From: [Tom And Kelley](#)
To: [Chace Pedersen](#)
Subject: CU-23-00002, The Outpost
Date: Wednesday, November 29, 2023 10:39:40 AM

We have owned our family cabin for over 26 years within the Sunshine Estates Community at 471 Sandelin Lane, Ronald, WA, which is adjacent to the proposed project CU-23-00002, The Outpost.

We request that CU-23-00002 be denied based on the above concerns.

**CONCEPTUAL SITE PLAN
MULTIPLE PARCELS**

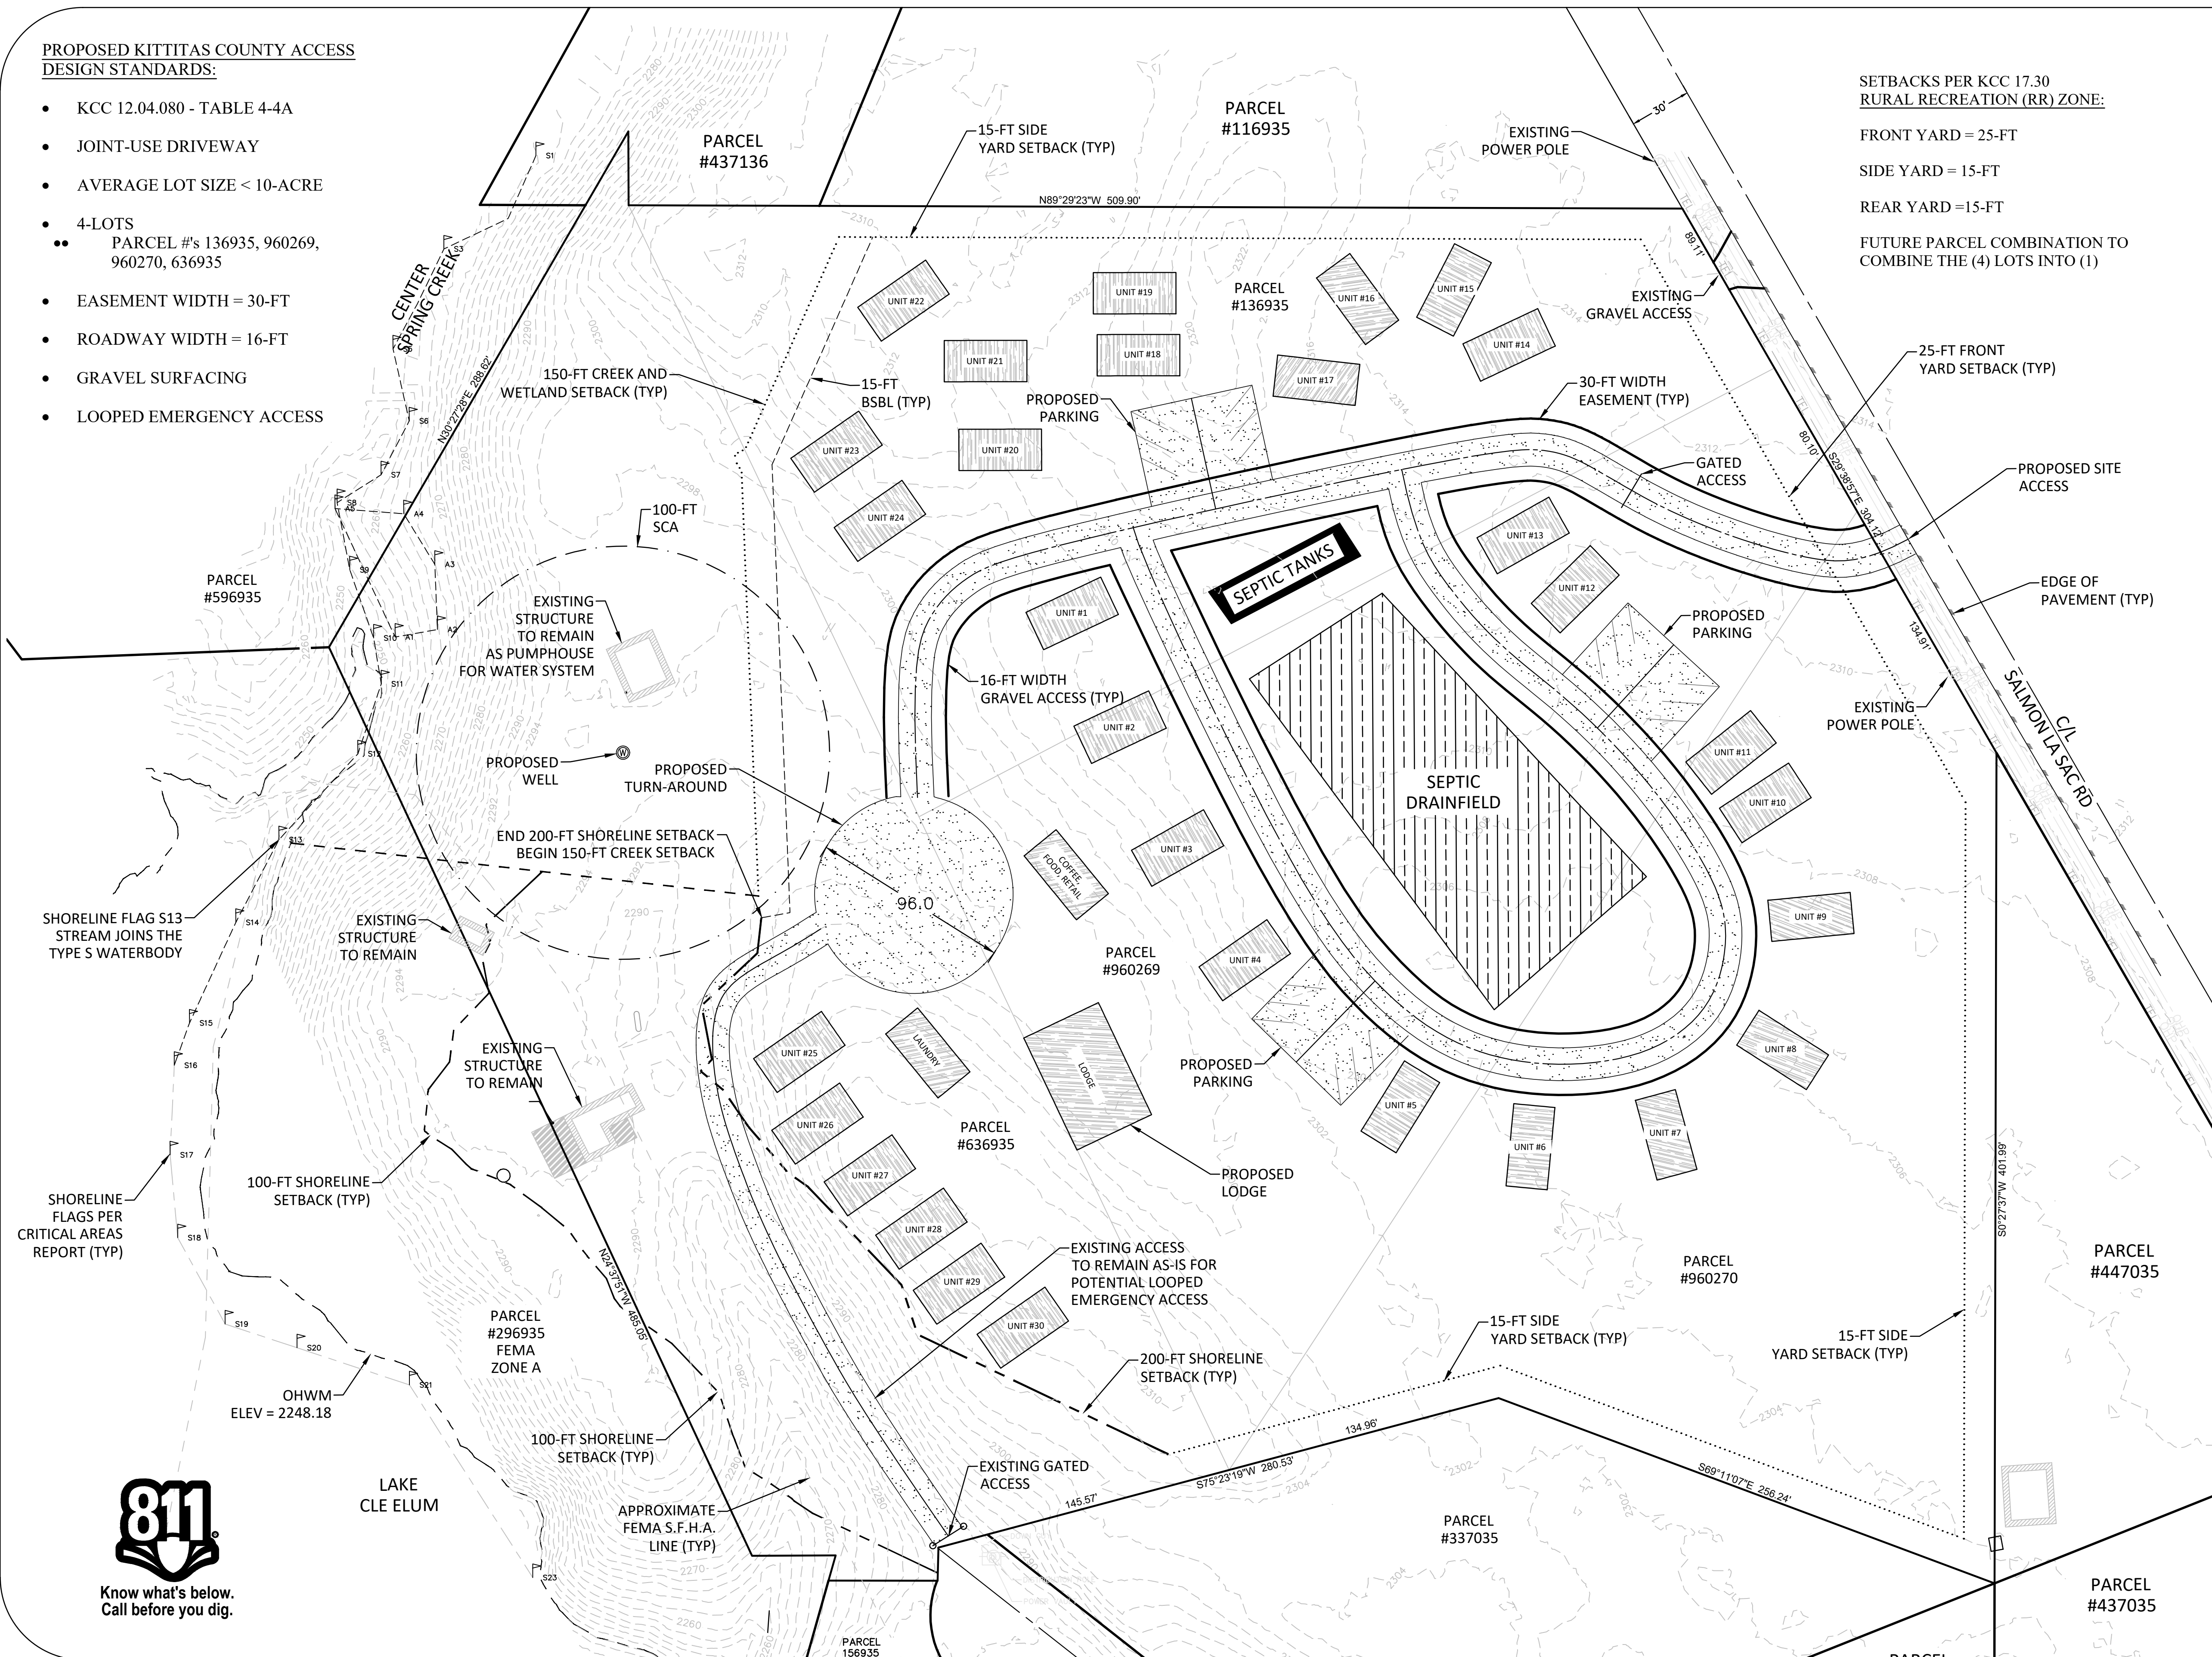
- The proposed access for emergency services is through Sunshine Estates Community land. This is a private road that may not meet county width standards for that type of access and should not be considered in any way for this type of access to a property located outside of Sunshine Estates' boundaries.

Should the project be allowed to proceed we request, at a minimum, that an 8 foot permanent privacy fence be required to surround the property to help protect our HOA road and any adjacent residential properties from both foot and vehicle traffic.
